RECOMMENDATION FOR PLANNING AND DEVELOPMENT COMMITTEE

APPLICATION NO: 3/2012/0420/P

PROPOSED OUTLINE APPLICATION FOR A RESIDENTIAL DEVELOPMENT ON LAND NORTH AND WEST OF LITTLEMOOR, CLITHEROE

9W7186 SK016

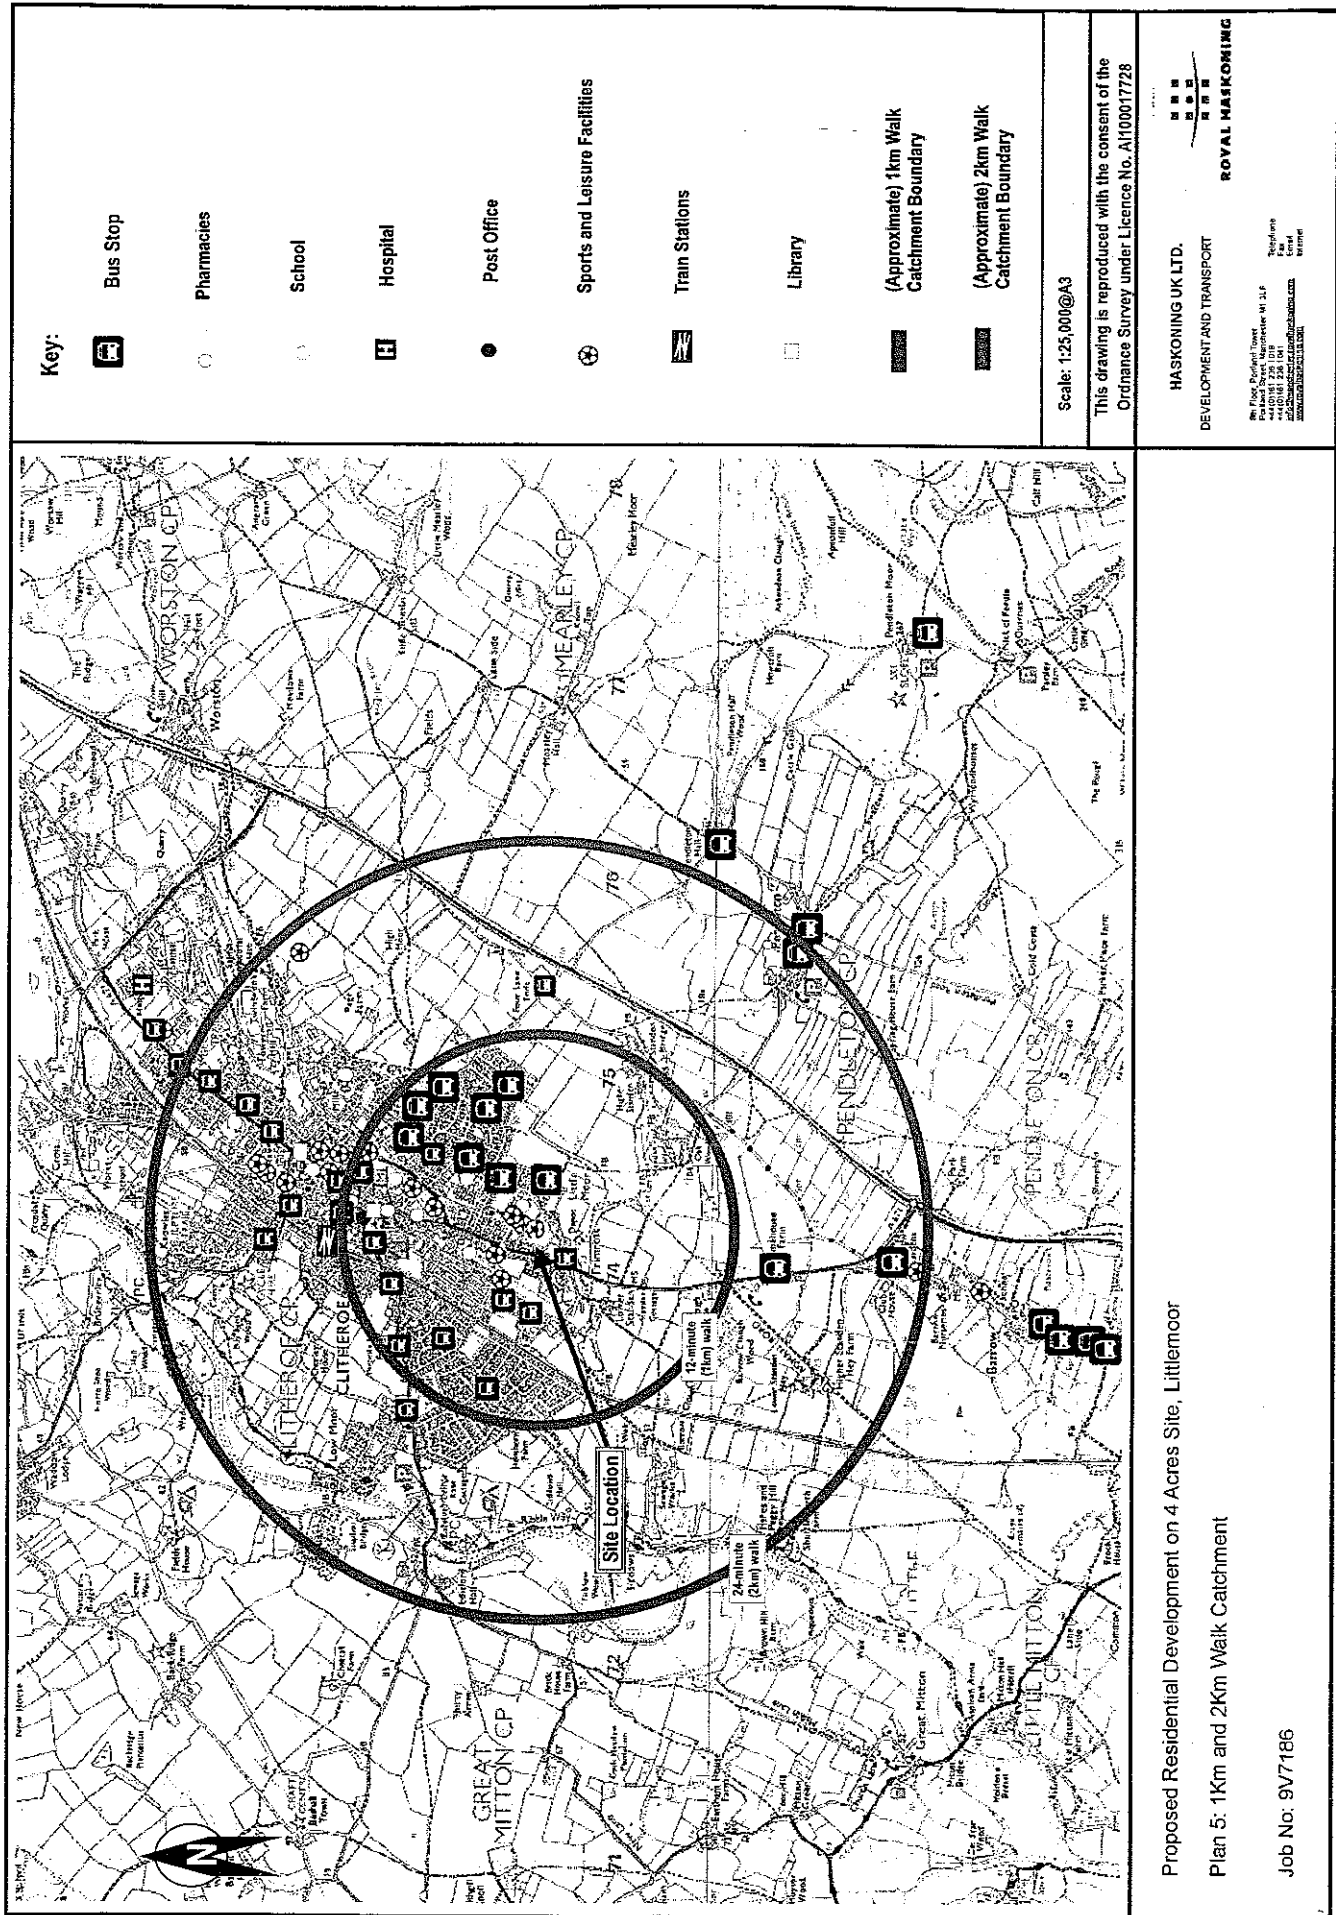
The initial design contained in Drawing 9W7186 SK016 Revision A, provides an indication of the highway parameters for the design of a suitable vehicular access.

The initial access design indicates that visibility splays of 2.4m by 43m can be achieved from the site onto Littlemoor Road. I am satisfied that this is a suitable provision and that it can be

However, there are some aspects of the initial site layout that should be revised to enhance highway safety.

achieved in this instance. In addition, the recent implementation of a 20mph Speed Limit on Littlemoor Road will assist with compliance.
